Application for a non-material amendment following a grant of planning permission.

Replacement Garage with Annex Over and Change of Use of Land to Form Part of Residential Curtilage

Reference number:	<input type="text" value="20/01280/FUL"/>
Date of decision	<input type="text" value="02/12/2020"/>

Relocate the garage block (as per the approved development) slightly further east to align the front façade with the rear façade of the main house.

Drawing No: **20-2265-(90)02** Revision: **F**

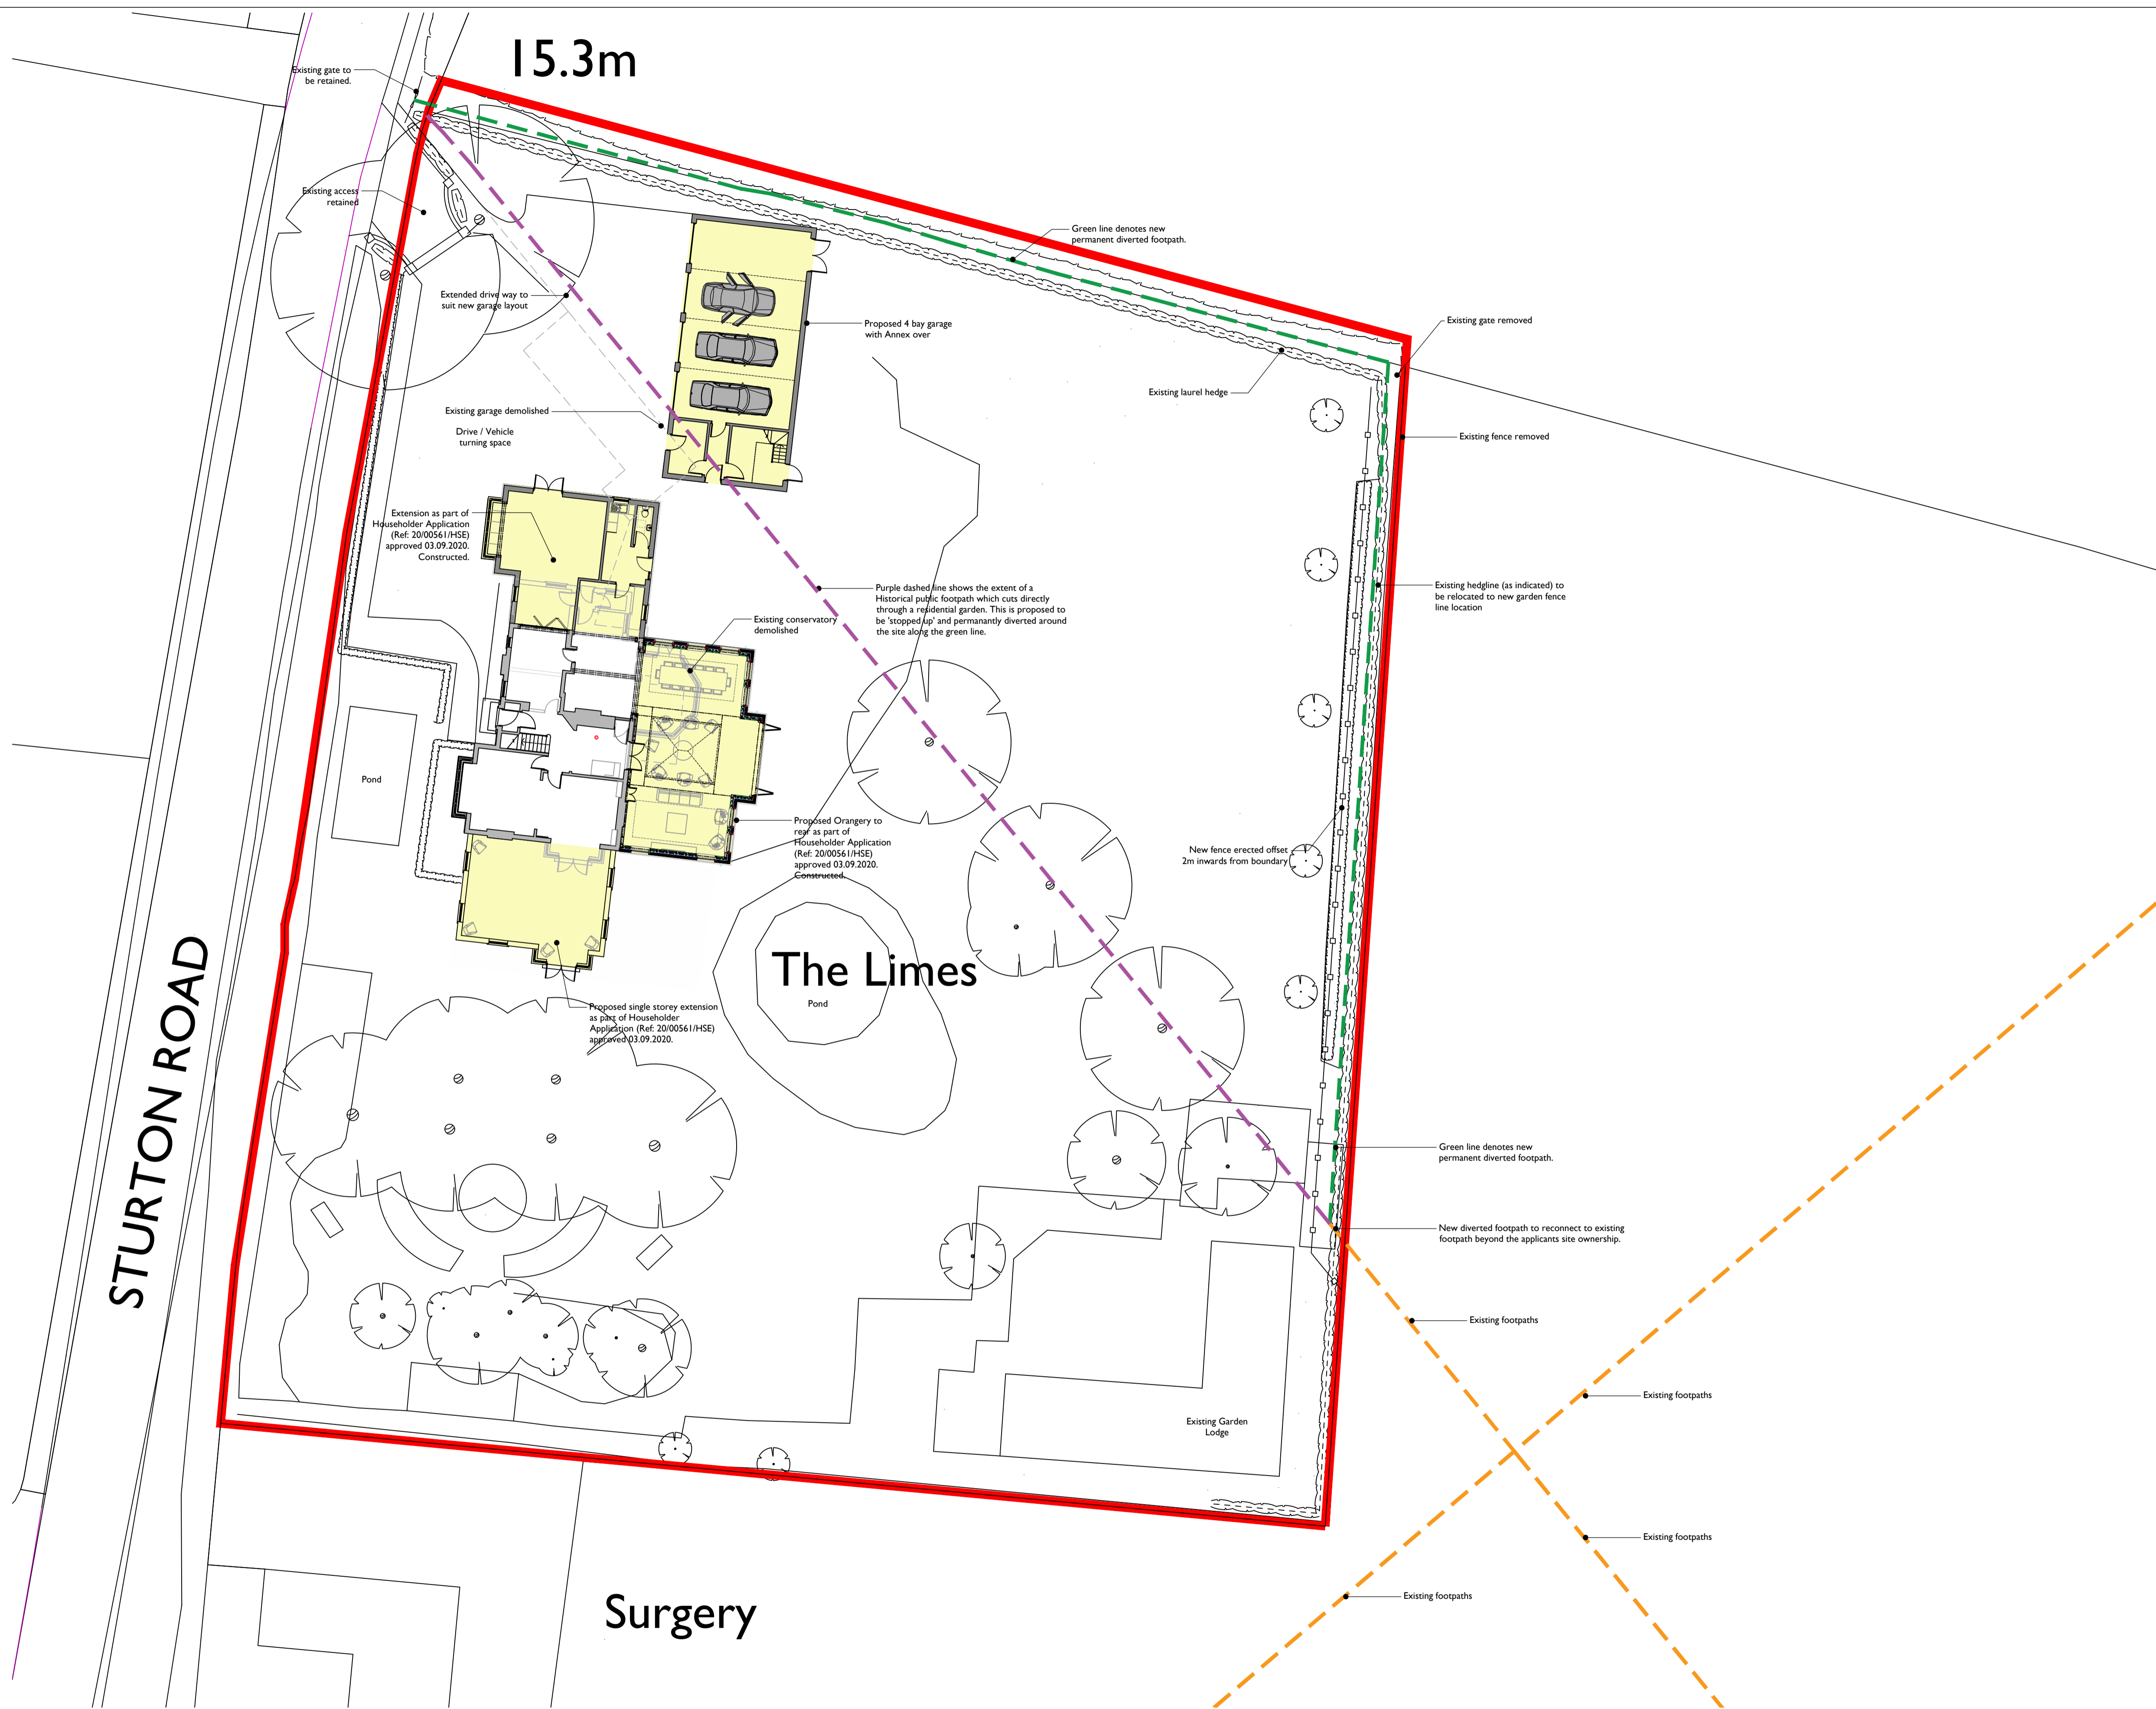
This is primarily to maintain views out of the house bedroom windows now the extension (approved under separate householder application) is constructed and they are enjoying the view.

20-2265(22)-005-G-Proposed Garage Layout and Elevations
20-2265-(90)02-F-Proposed Site Layout
